From: William Clark
To: Jean Fraser
CC: David Margolis-Pineo
Date: 4/17/2014 3:49 PM
Subject: Fwd: RE: Plat - 118 Congress Street, For Final Approval

City of Portland Technical Manual 268
Section 13 - Boundary Survey
Adopted 7/19/10. Rev. 6/17/11

**STANDARD BOUNDARY SURVEY**  
 ON  
 118 CONGRESS STREET, PORTLAND, MAINE  
 MADE FOR  
**THERIAULT/LANDMANN ASSOCIATES**  
 PORTLAND, MAINE

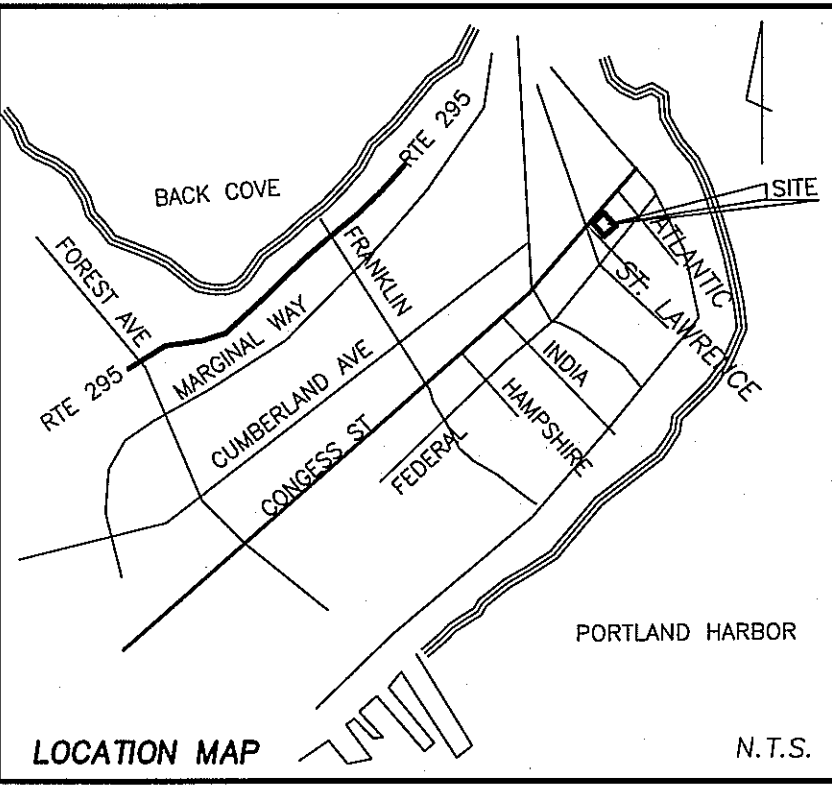
From the Technical Standards. Yes they are required on property corners.

When State Plane Coordinates are required, the **State Plane Coordinates (to the nearest hundredth of a foot) of two survey property corners shall be displayed for any two property corners in the project** which are the farthest distance apart. Please contact the Public Services Engineering Division for assistance in providing Survey Control Points or GPS Base Station Support.

Thanks Jean. You might remind DRS that the ordinance requires coordinates on two monuments in the City, not at two corners of the lot. We did add the extra coordinates to make sure things went smooth.
